**WEST YORKSHIRE  
POLICE**

**Designing Out Crime Officer**

<p>To: Richard Riggs – Kirklees Council</p>	<p>Ref: 2023/90024 Date: 24<sup>th</sup> April 2023</p>
---	---

**Site Location: George Hotel, St Georges Square, Huddersfield, HD1 1JA**  
**Application type: Hotel**

3) Proposed West Elevation A
1 : 100

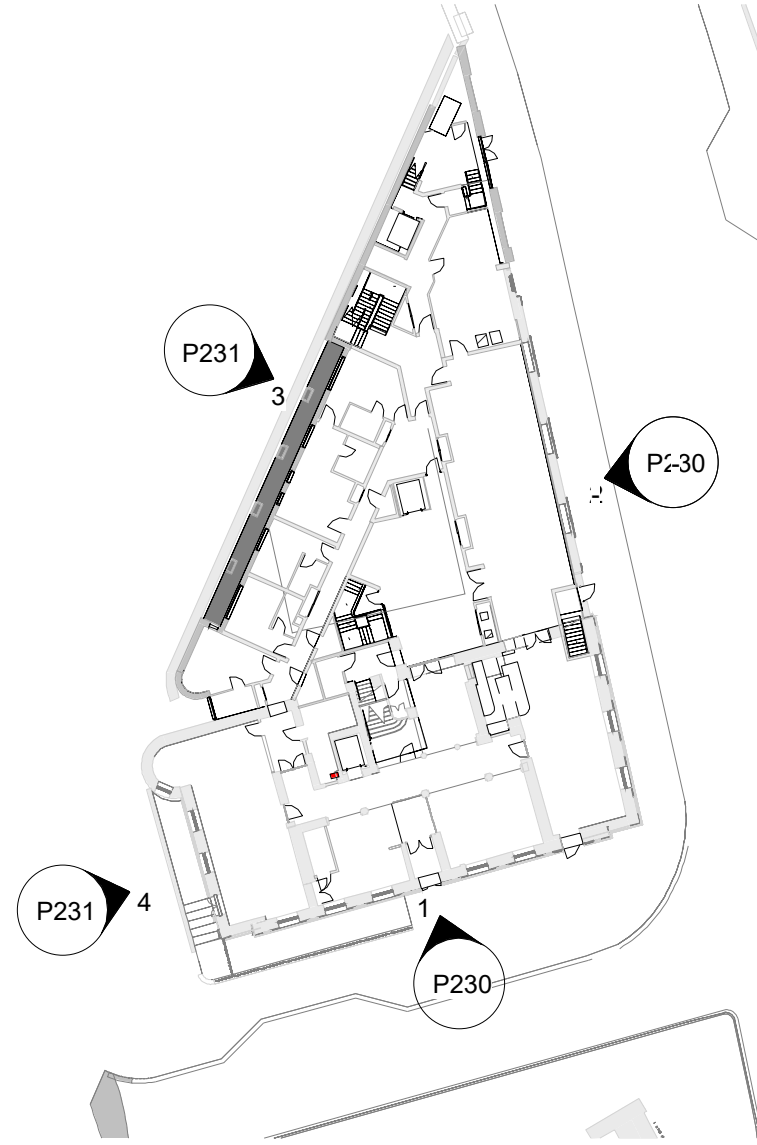
As this is a significant Town Centre location next to a transport hub, it should be noted that the shown external lighting for the West elevation would not be supported by Police. The shown low level bollard lighting spill is not conducive to facial recognition and will not assist any CCTV or witness to an incident in this area. The applicants are encouraged to discuss the lighting specifications with a Designing Out Crime Officer.
